From: Zac Denton
Sent: 25 July 2019 09:34
To: Planning Scanning
Subject: FW: Mistletoe Farm, Horsemere Green Lane. CM/13/19/RES; Revised Drainage Proposals

Subject: FW: Mistletoe Farm, Horsemere Green Lane. CM/13/19/RES; Revised Drainage Proposals
Importance: High

From: kazys <[REDACTED]>
Sent: 17 July 2019 09:54
To: Laura Gibbons [REDACTED]
Cc: Edward Rees [REDACTED]; Zac Denton [REDACTED]
Subject: Mistletoe Farm, Horsemere Green Lane. CM/13/19/RES; Revised Drainage Proposals

Drawing Title Engineering Details Drainage Strategy (with Ditch)				
Drawn KN	Checked	Scales 1:250	Paper Size A1	Date 07.19
Job No. ES1820	Drawing No. 602-04	Revision B

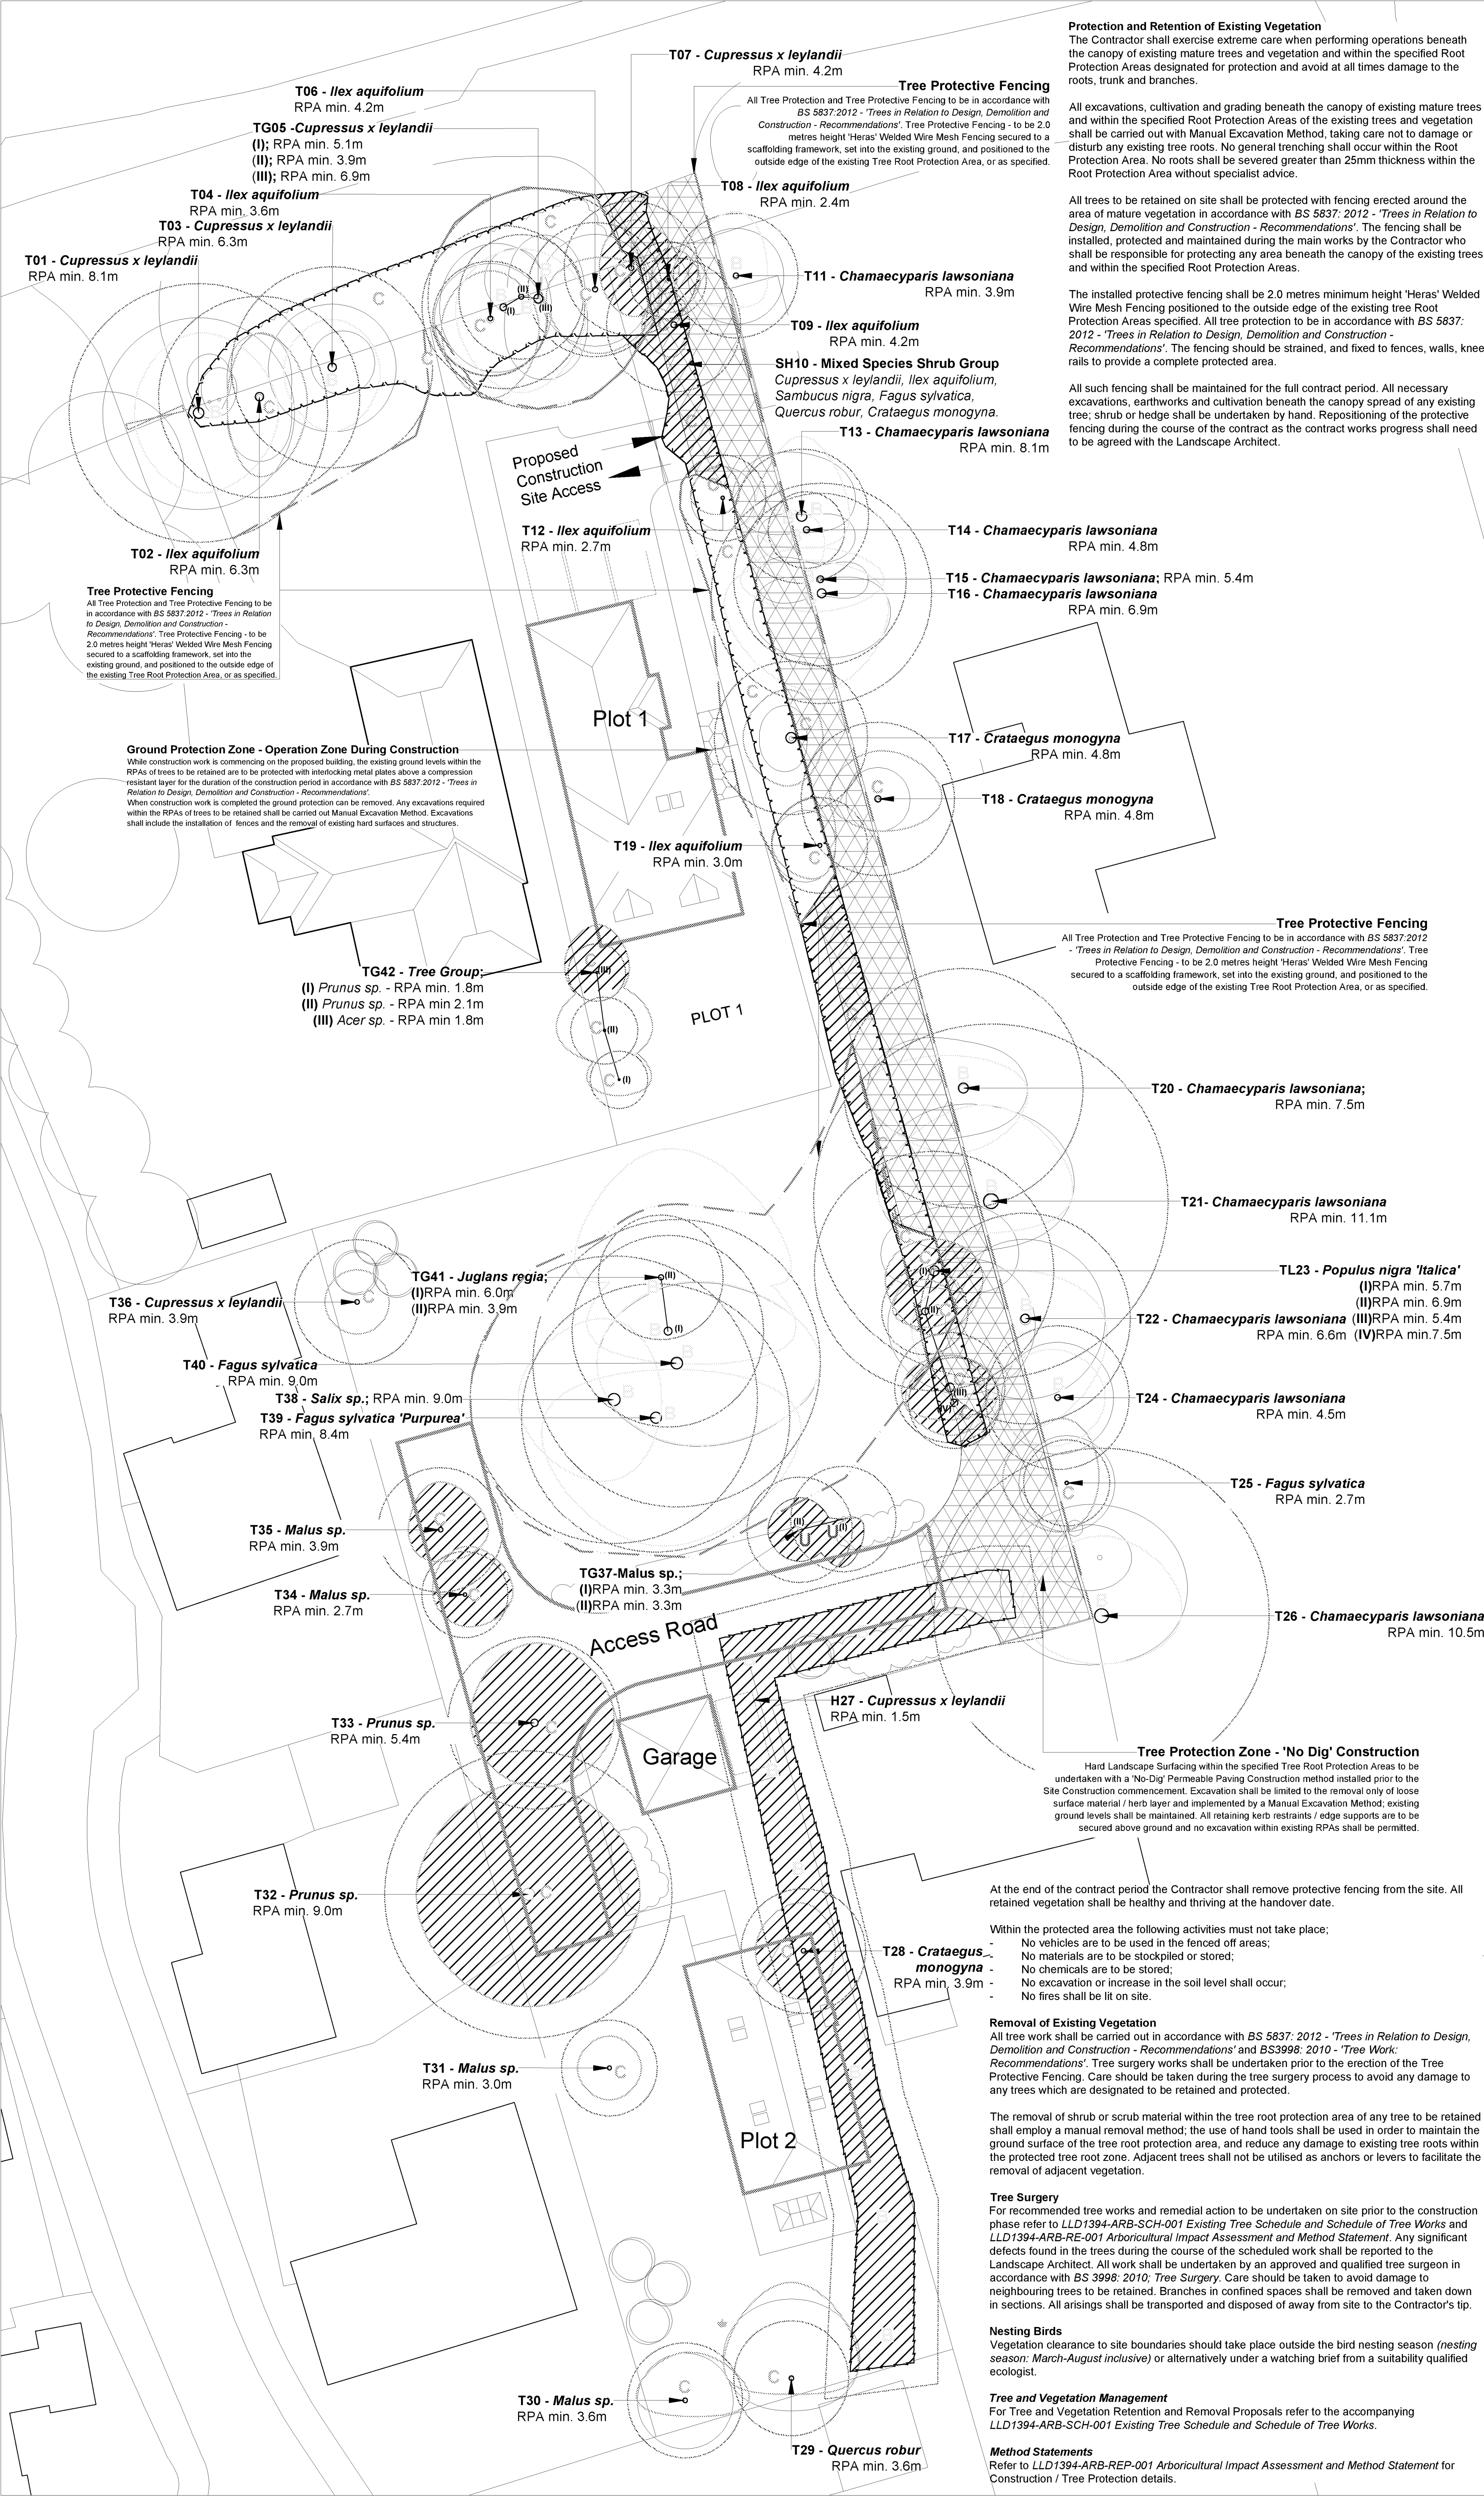
Thank you for sending over the revised plan. I believe there is some conflict between what you are proposing and the tree protection plan (attached).

The permeable paving for plot 2 looks like it could only be located in the T furthest round on the road rather than at the junction of roads 1 and 2. The swale also appears to be within a no dig area.

Thank you for your comments. I was under a misapprehension regarding the RPZ so having cleared that I have put together a revised proposal which addresses your comments on the RPZ. Hopefully you find this revised proposal accords with your thoughts and you are able to advise your planning colleague that we have reached a drainage solution. As always, if you have any further concerns please contact me. Many thanks.
